Tween Bridge Solar Farm

9.10 Statement of Common Ground with National Highways

Document Reference: 9.10

Revision 4

Drawing Ref: Environmental Statement Volume 4, Figure 2.2a: Indicative Operational Layout Plan

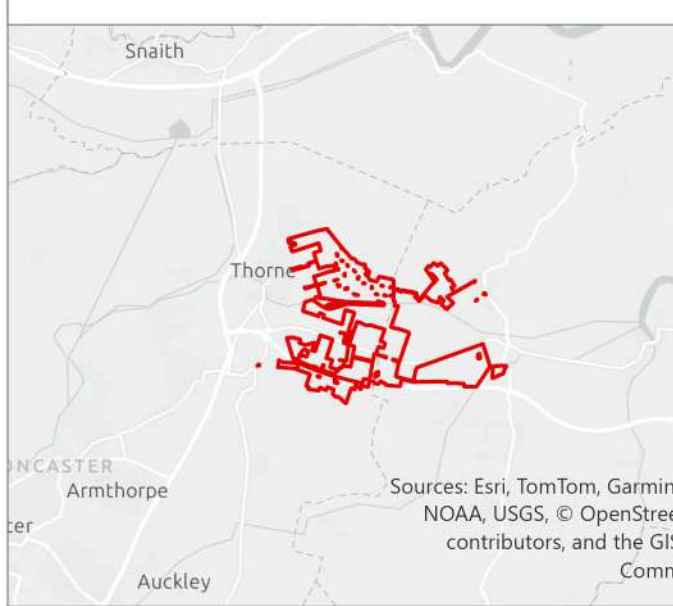
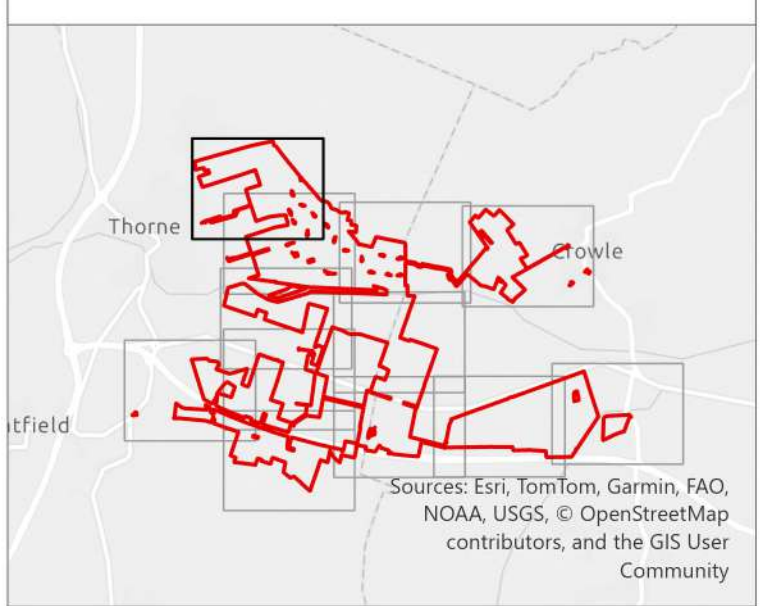
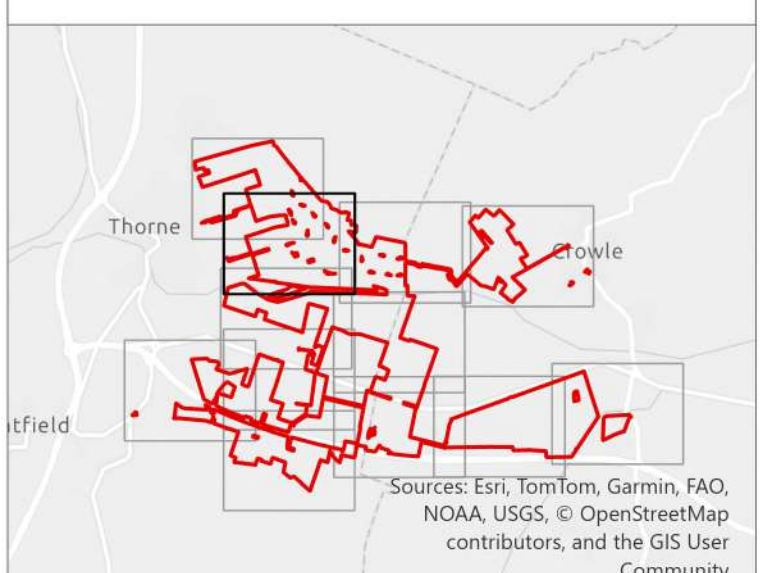
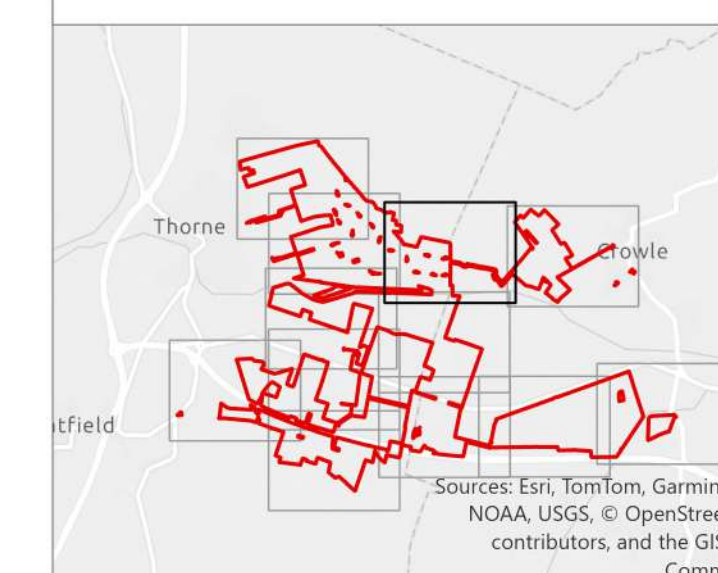
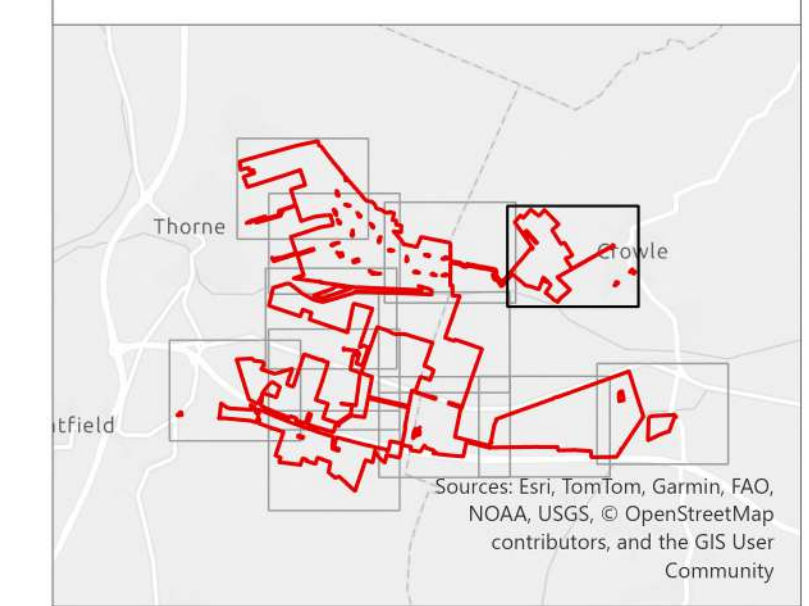
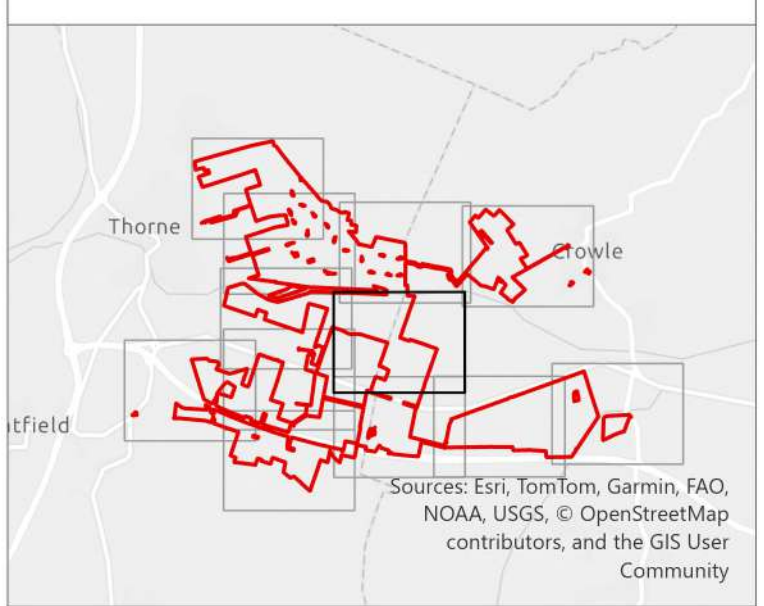
<u>Requirement 9 (fencing and other means of enclosure)</u> The Applicant's outline indicative layout plans [APP-134 & 135] demonstrate the extent of fencing and enclosures bounding the SRN (for example, see field references D2, D6, D3, D5, D10, D11, D12, D13 etc). Fencing adjacent to the SRN must be designed in accordance with the Design Manual for Roads and Bridges (DMRB) in order to achieve the necessary safety standards, without which pose unacceptable risk to road users. NH requires the following amendment to Requirement 9 in order to ensure the necessary temporary and permanent fencing meets the required design standards: <i>9(1) No phase of the authorised development may commence until written details of all proposed temporary fences, walls or other means of enclosure, including those set out in the outline construction environmental management plan, for that phase have been submitted to and approved by the relevant planning authority or both relevant planning authorities (as applicable) or National Highways in respect of fencing to be erected adjacent to the strategic road network.</i>
